Frodsham Solar
Statement of Common Ground with the
Environment Agency

December 2025

PINS Ref: EN010153
Document Ref: EN010153/DR/8.17
**Planning Act 2008; and Infrastructure Planning (Applications:
Prescribed Forms and Procedure) Regulations Regulation 5(2)(q)**

Revision P01

Drawing file: published-documents / EN010153-000101-6.2_ES Vol 2 Appendix 2-1 Indicative Watercourse Crossing Schedule.pdf

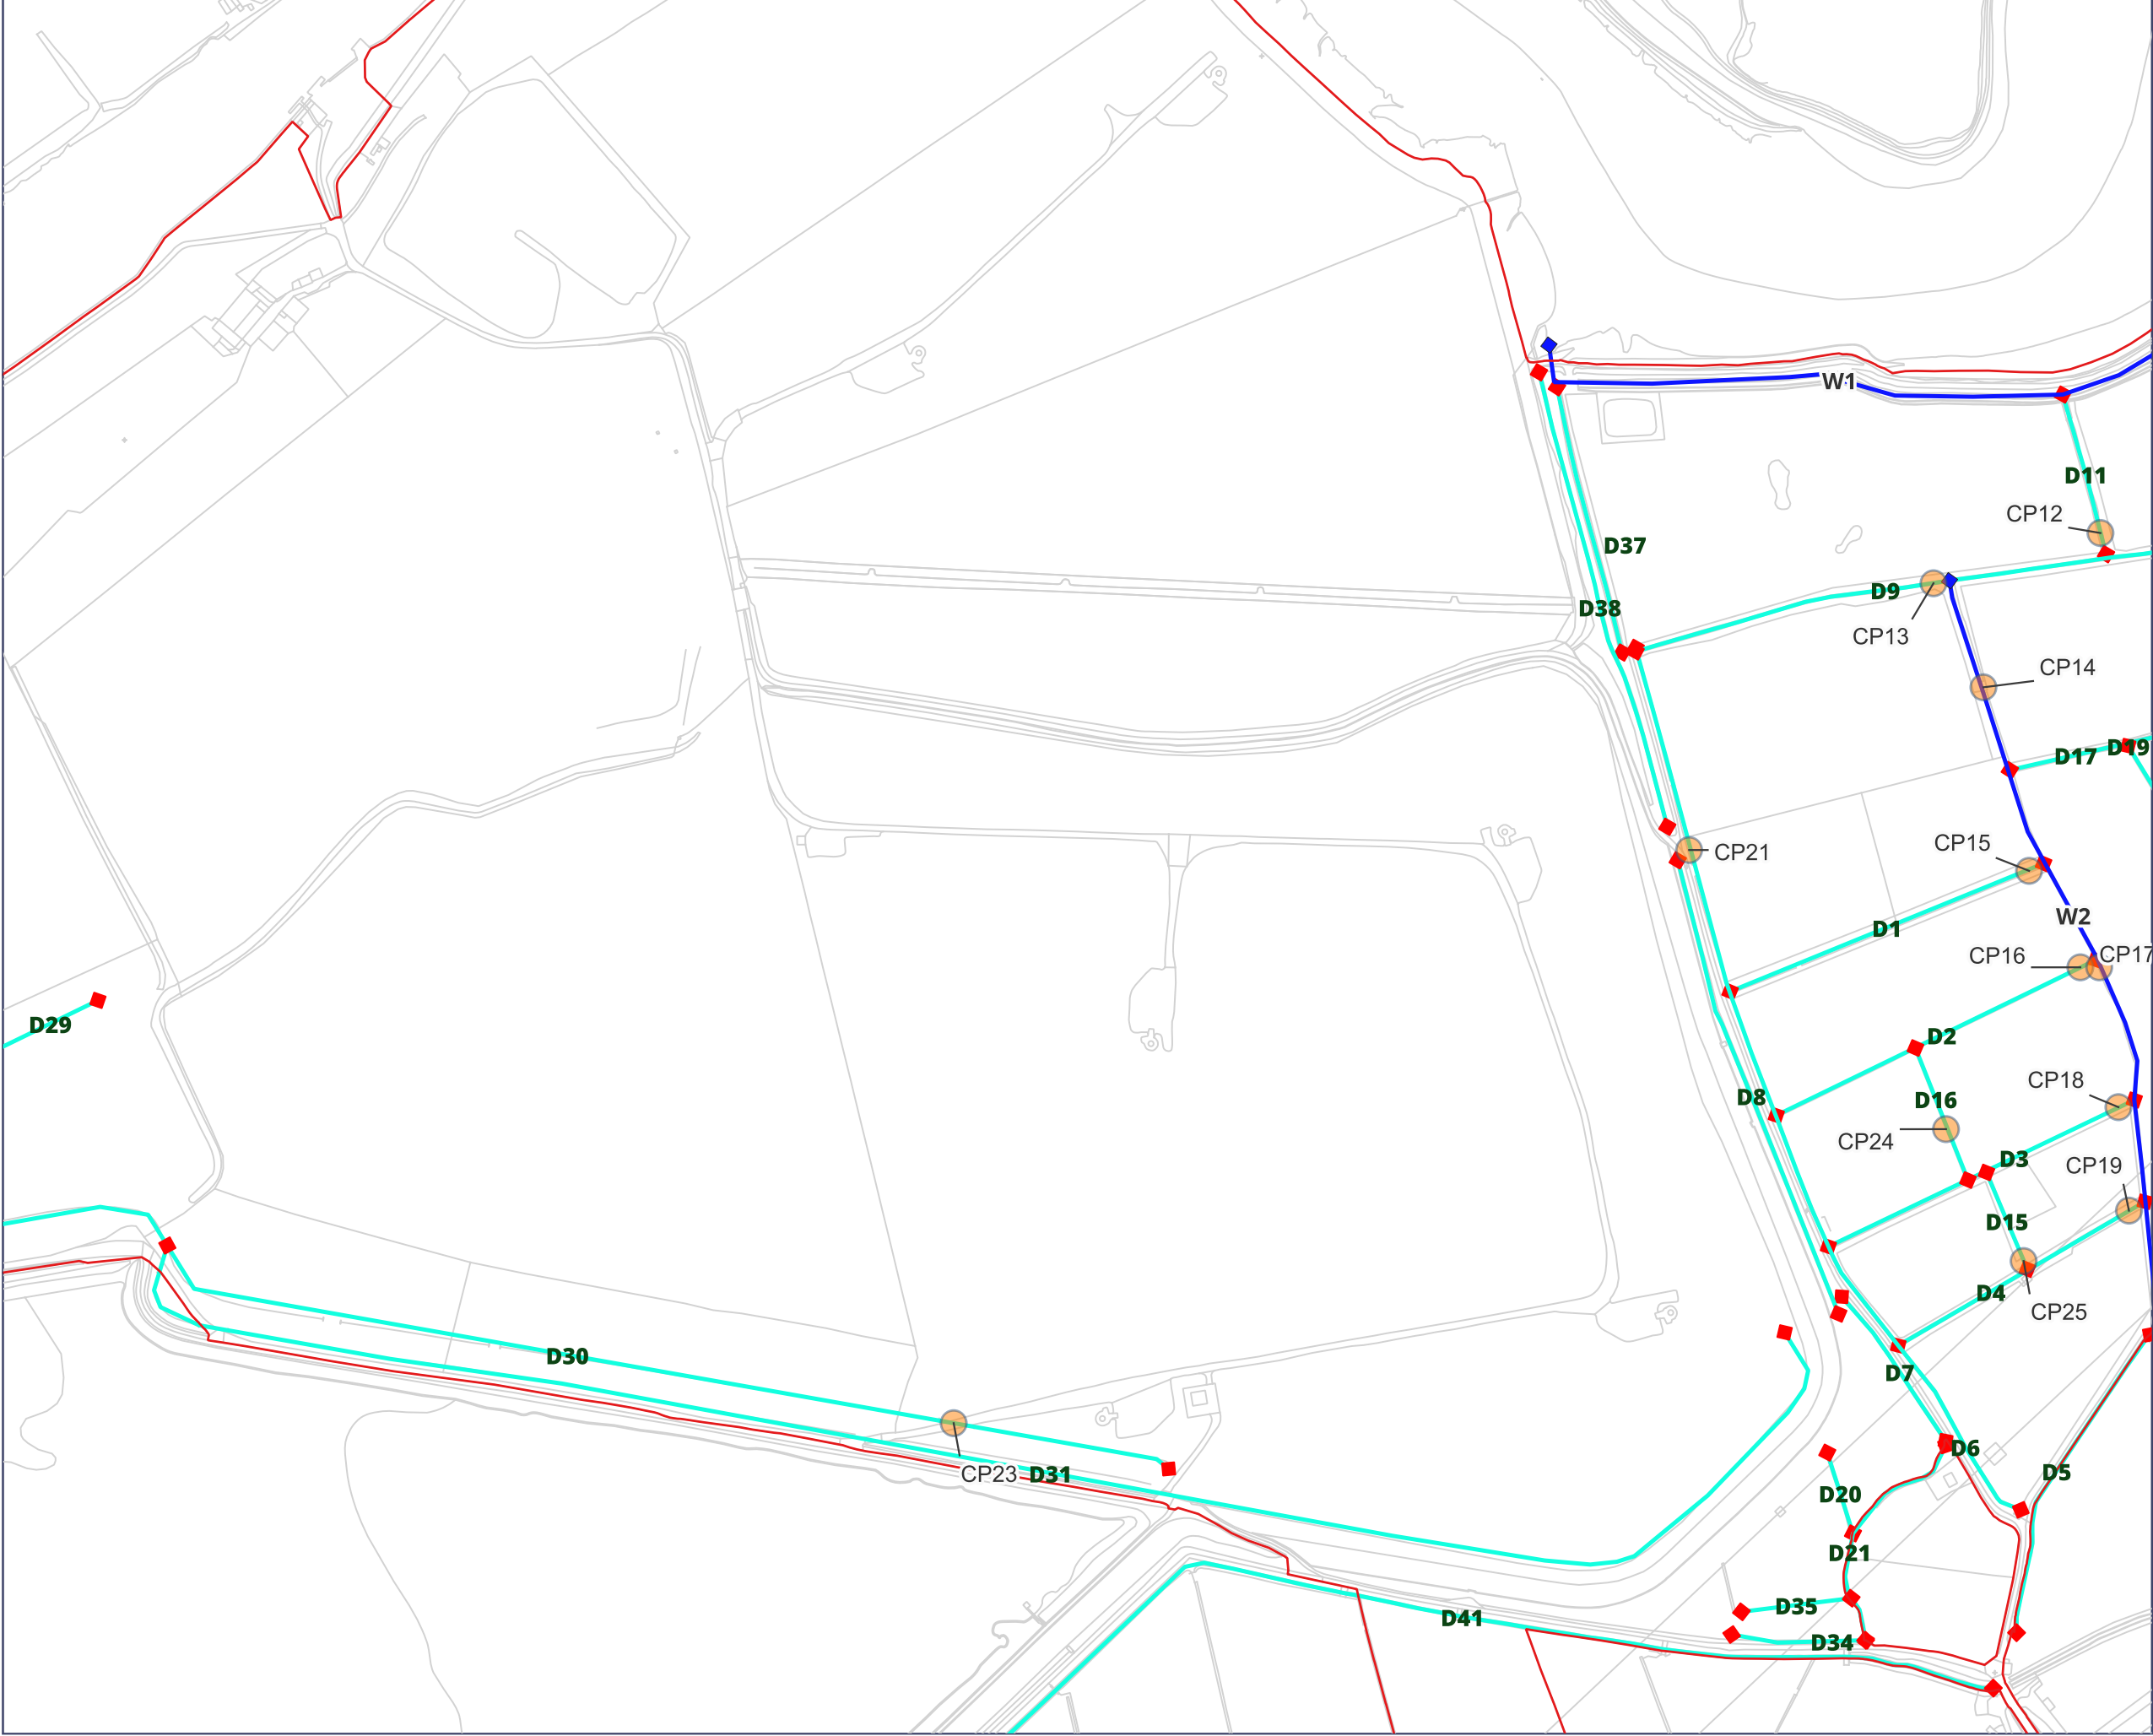
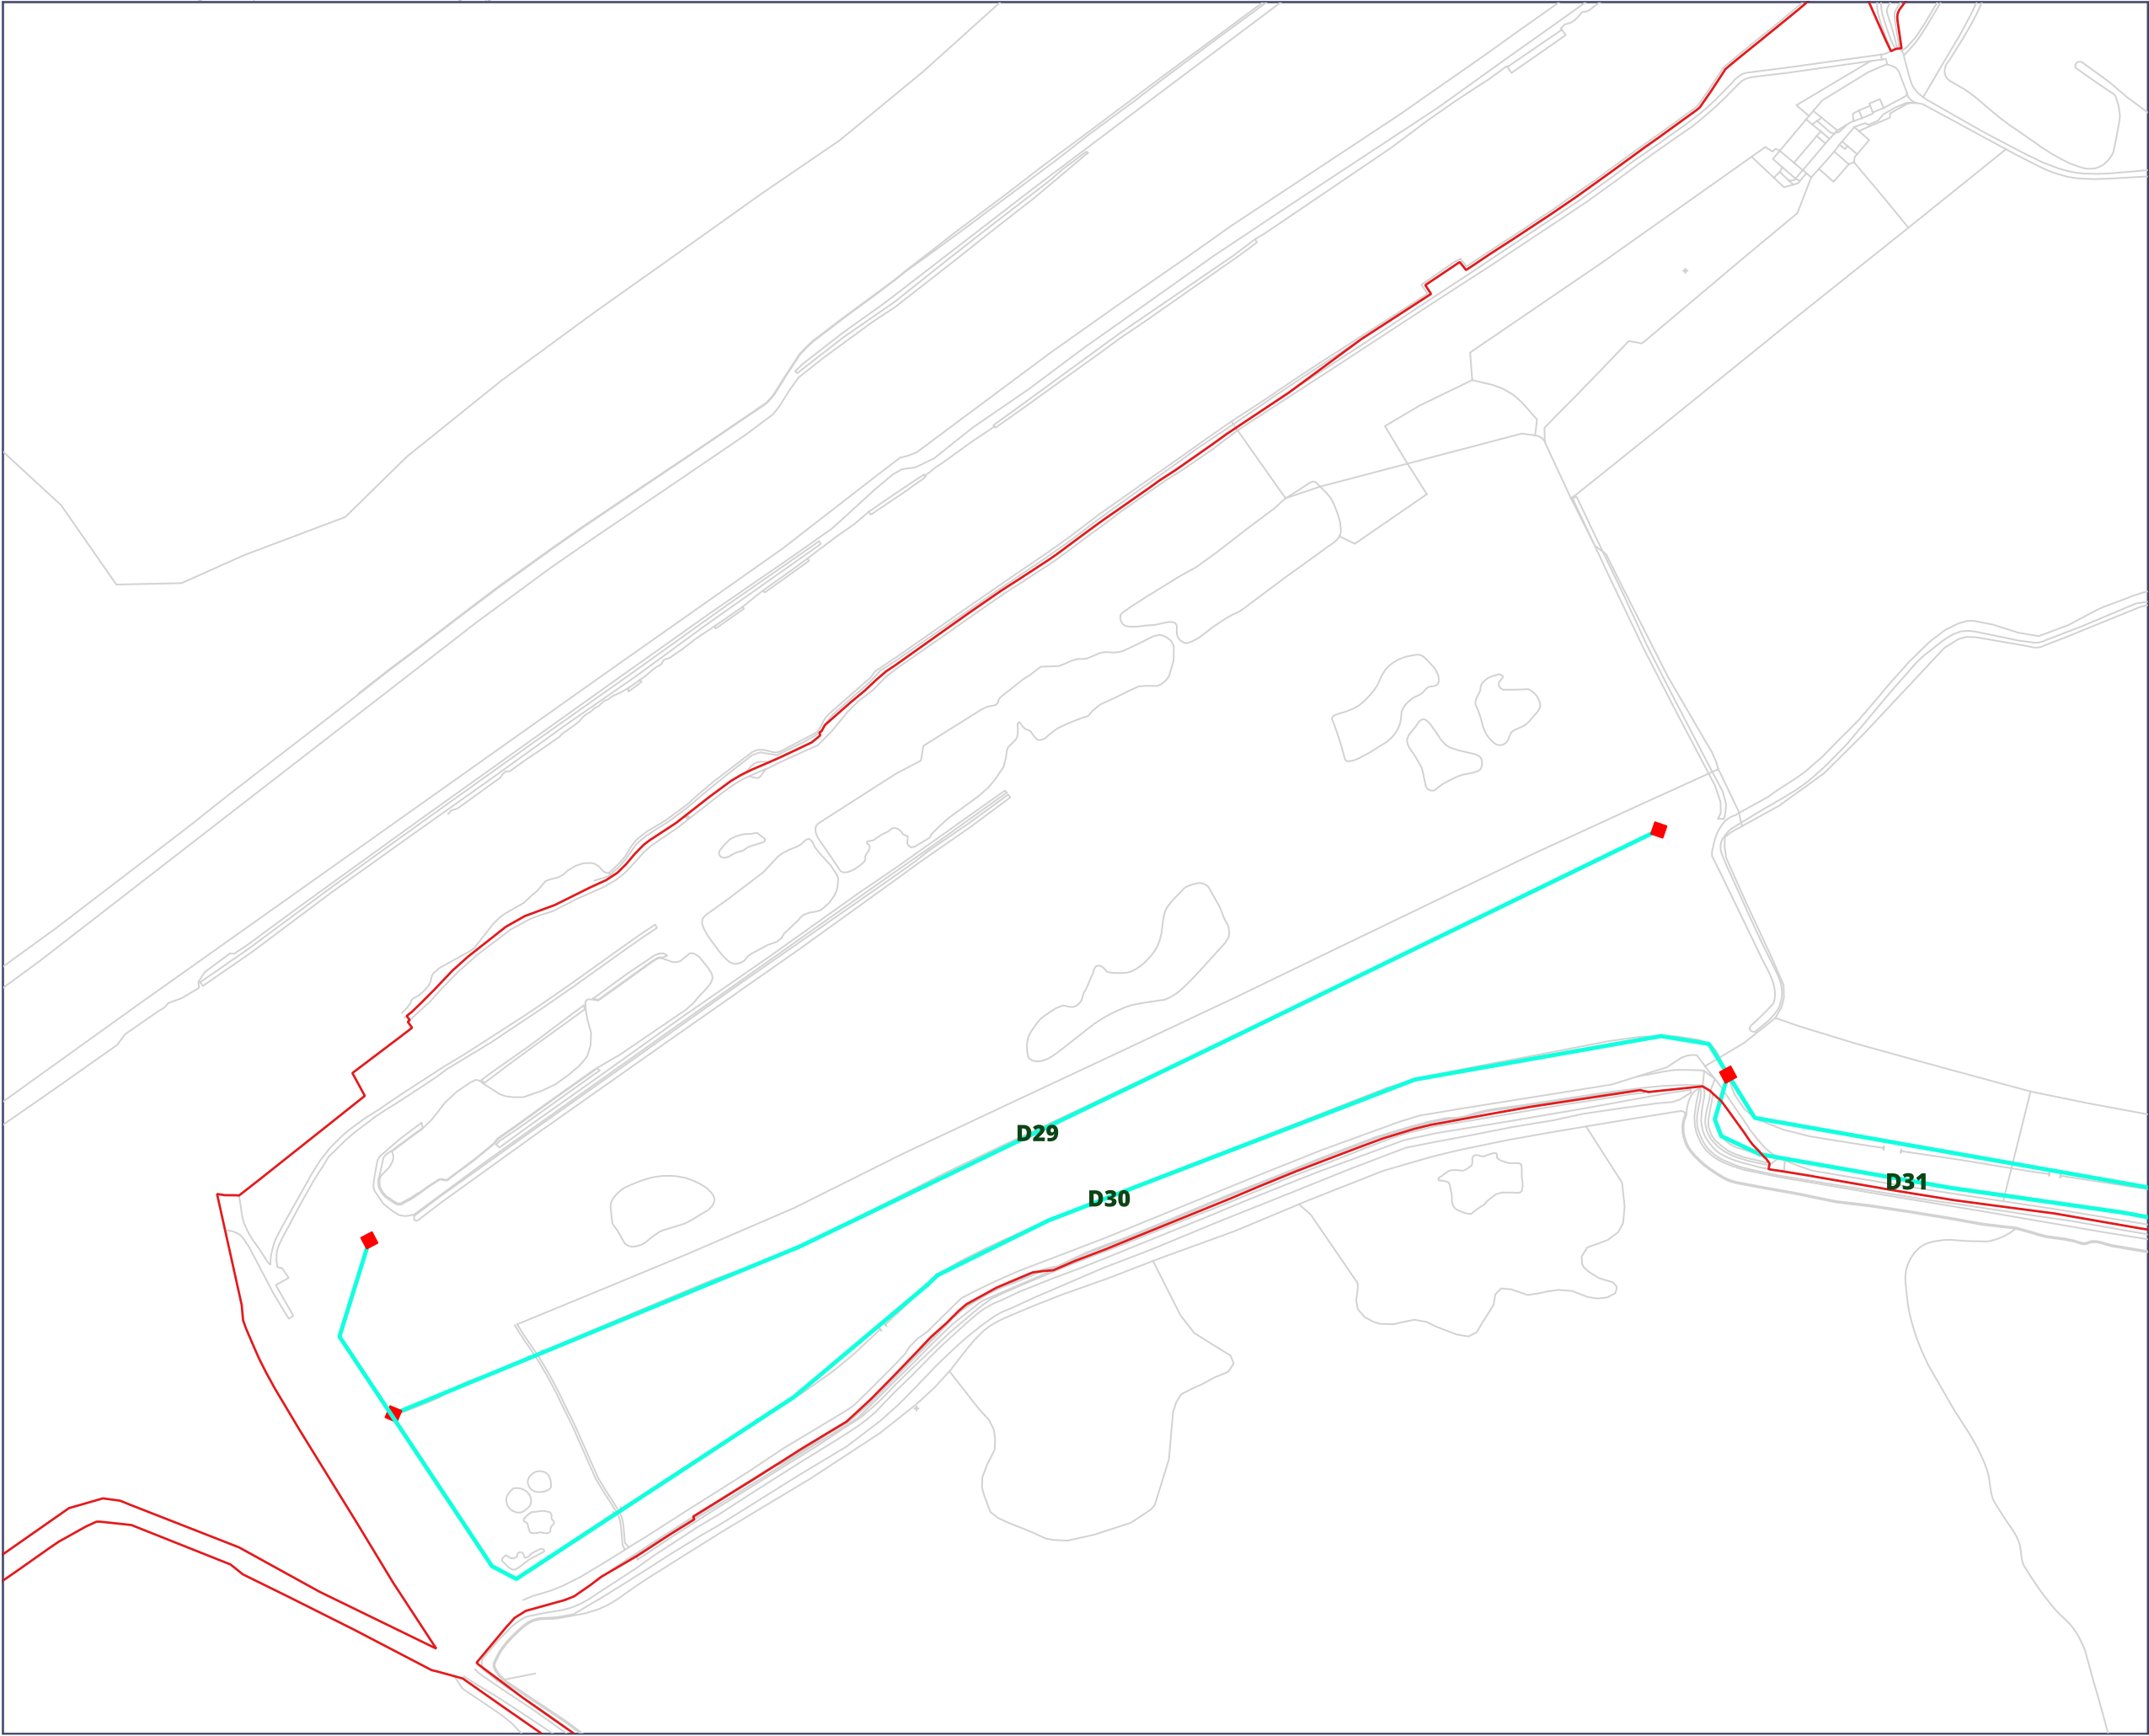
Topic(s): Water Quality and Resources, Flood Risk and Drainage, Ecology and Biodiversity				
012	<p>The Applicant's approach to designing watercourse crossings.</p> <p><i>EA Issue ID: EA007</i></p>	The EA has concerns about the position of bridge abutments and soffit levels, and that these will reduce conveyance of water during high flow conditions, preclude access to, and threaten the stability of the riverbanks.	The Applicant has provided the EA with additional technical information including a technical note and cross-sections, and has undertaken a site visit alongside the EA to discuss the issue.	<p>Under discussion</p> <p>EA Agreed on design of CP14</p>

Ref.	Matter	EA Position	Applicant Position	Status
		<p>The EA request that a soffit level at least 0.6metres is provided from the bank top, as set out in the Standard rules SR2015 No 28 guidance. The EA require a 2m offset for the abutments to ensure that geomorphological processes aren't impacted.</p>	<p>The Main River bridge crossings CP14 and CP17 will be constructed to provide a 600mm freeboard between the bridge soffit and top bank level, and abutments set 2m back from the bank, in line with the EA's requests. This change has not been made at CP22, as there is insufficient space to enable a 600mm freeboard. However, it was agreed with the EA that the reduced freeboard provided for by the Applicant in the design would still provide betterment at this existing crossing by providing a new clear span bridge which is currently culverted.</p> <p>Schedule 23 of the draft DCO provides protective provisions for the protection of the Environment Agency. These protective provisions require the Applicant to submit and obtain approval of the bridge crossings (as a specified work) prior to the commencement of their construction. At present the EA have not agreed to the protective provisions.</p> <p>Table 5-4 of the oCEMP was revised at Procedural Deadline B (REP2-015) to include the above design requirements for the main river bridges such that the above design parameters are secured by the DCO.</p>	<p>and CP17 – still reviewing CP22.</p>
